Subject: BR/256/19/PL

Proposed First Floor Plan

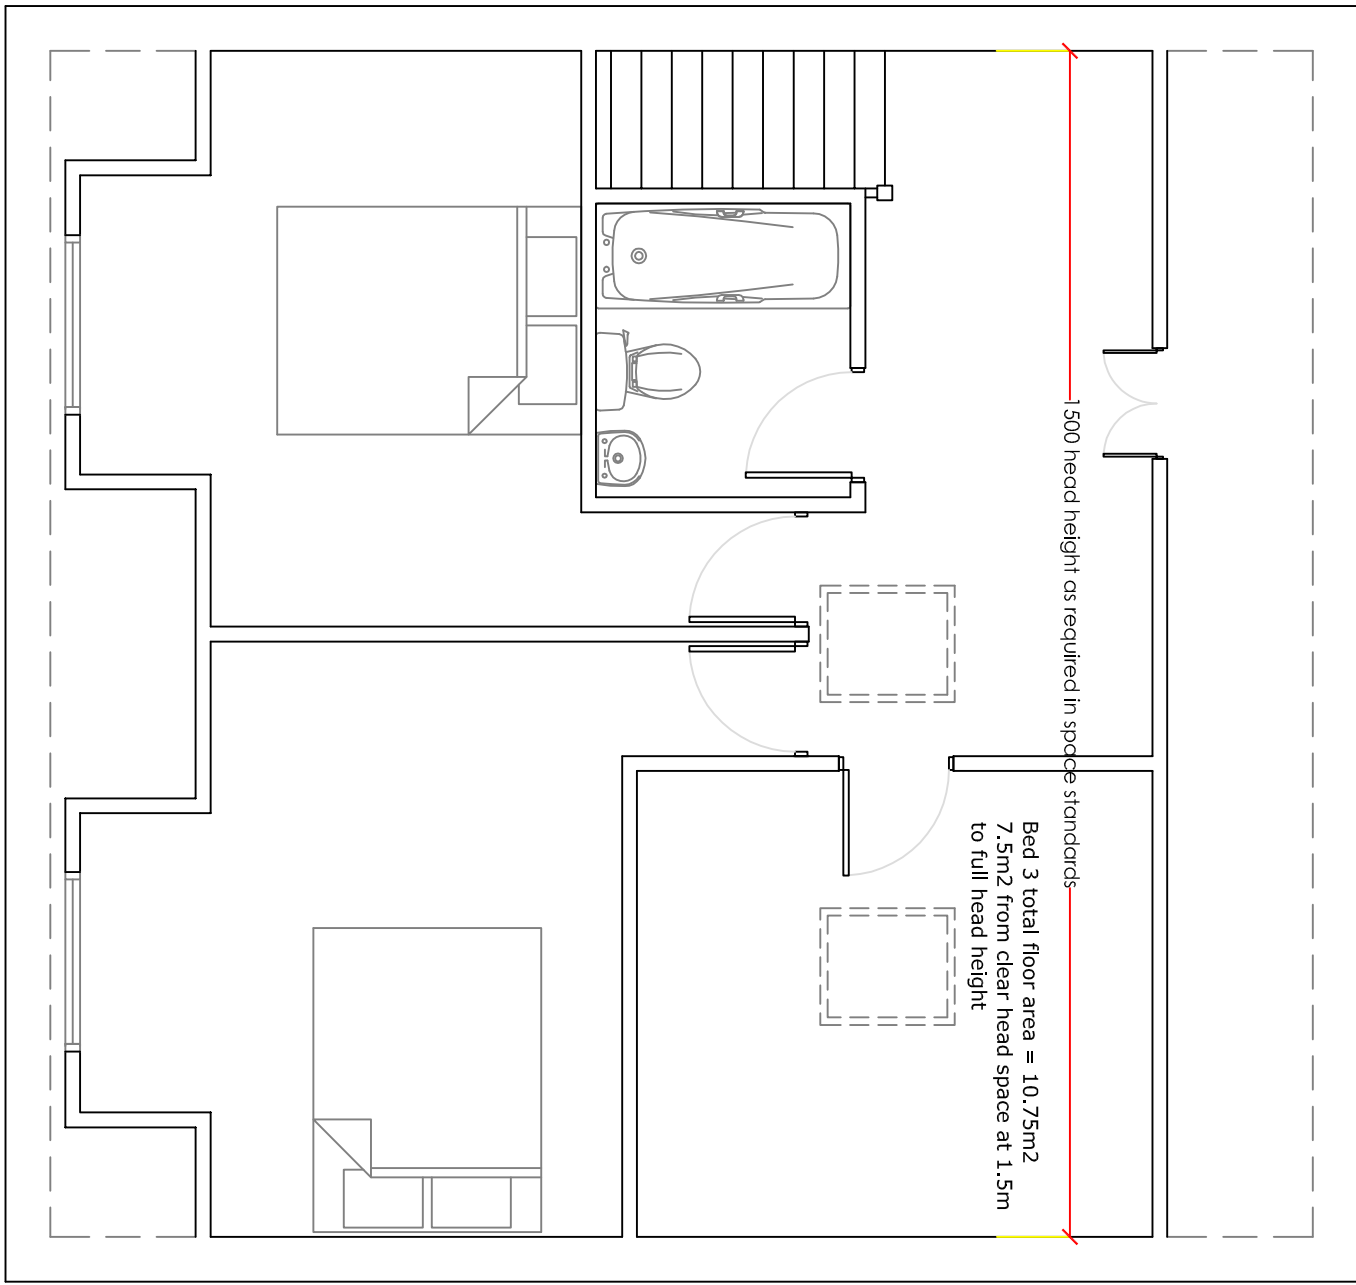
- 2) Could you please provide a line on the plans showing where the pitch of the roof cuts into the headspace? This will allow me to have a better understanding of how much internal space is usable.

- 3) Please label the third room accordingly – if this is intended on being a bedroom, please show it as such. If it is to be a study or a snug etc... then please label/furnish accordingly. This is to provide all parties with sufficient clarity in moving forward. I envisage if this were to be a bedroom then it would not likely meet with internal space standards.

Please find attached as discussed, please see notes on plans showing that bed 3 falls within space standards. We are happy to extend the determination deadline. Please do not hesitate to contact me if you require any further info.
